AB/3/22/HH

Mews House London Road Arundel BN18 9BH

Conversion of loft to habitable use including installation of 3 x dormers and roof terrace, addition of rendering, and alterations to fenestration/openings.

EAST ELEVATION PROPOSED

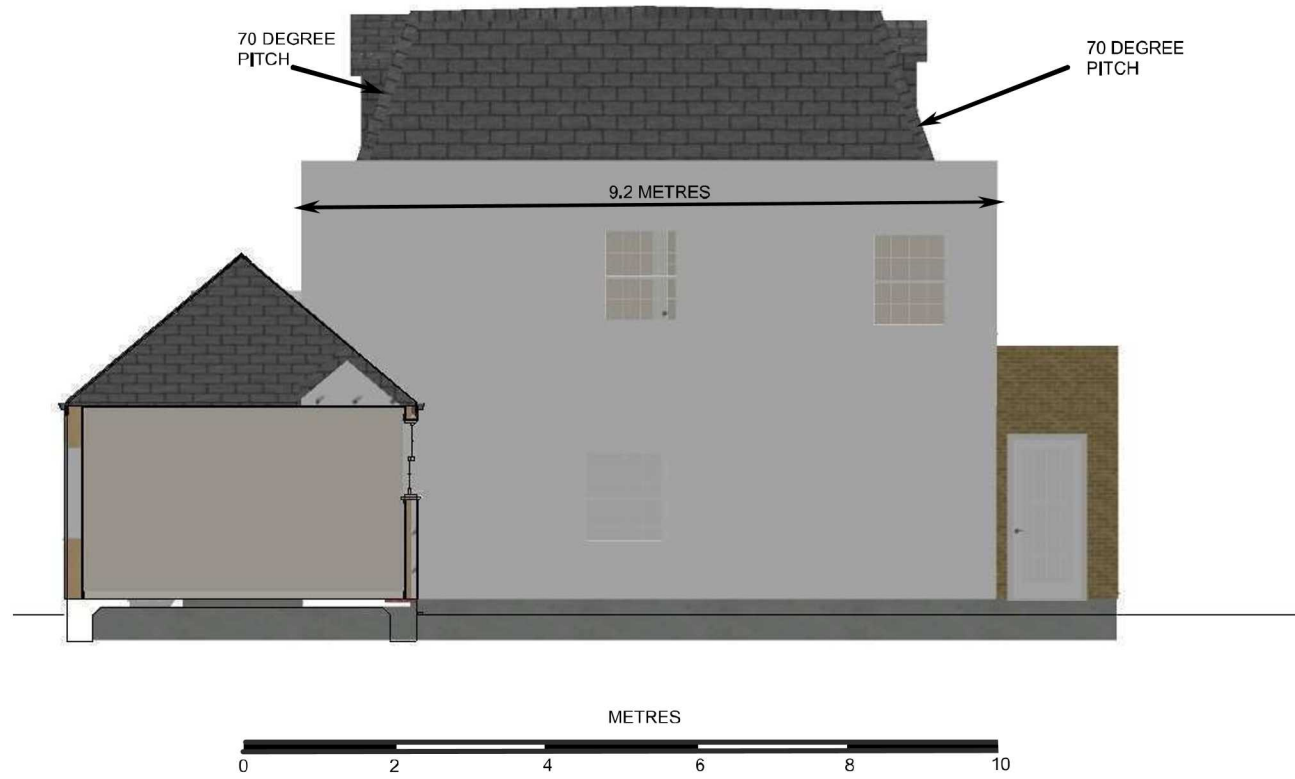
Whilst the description is to convert the (existing roof space) it would appear from the statements and plans that the actual proposal is to actually remove the existing roof and replace it with flat topped mansard roof. It is stated that this would begin 30cm inside the parapet wall and that the angle of the sloping part of the roof would be 70 degrees, and will rise 2 metres above the level of parapet wall. There would be a large dormer window to the south (rear) and 2 smaller dormers on the northern side. To the west there would be a door opening onto roof terrace with clear glass balustrade, replicating the roof terrace on the first floor (to the rear).

It is noted that for both the neighbouring terrace, and this building that the existing roofs are low and predominantly hidden behind a parapet so that they are not clearly seen from the road to the front. In introducing the additional floor and new roof space, the proposal would alter the scale and nature of the building so that it no longer was visually subservient. Such a feature would be clearly visible from the road to the front and would not reflect the general appearance of the neighbouring terrace, and would be harmful.

Further, the creation of a screened roof terrace next to it will exacerbate the incongruous nature of the proposals which will detract from the appearance of the building and be clearly seen from the road to its front and in the context of the neighbouring heritage assets. Whilst I note that there is already an existing terrace on the building, this is located to the rear and not clearly seen in the context of the road to the front. Although I do note that there is an area of very high trellis which is attempting to screen it.

The proposal is therefore out of character and would negatively impact upon the settings of the adjoining and nearby designated heritage assets and the character and appearance of the conservation area. This element is therefore considered to be harmful.

Whilst the eastern elevation is identified by the applicant as being a way of enhancing the appearance of this particular elevation. As it is repeated on the neighbouring house, this element seems to be acceptable.
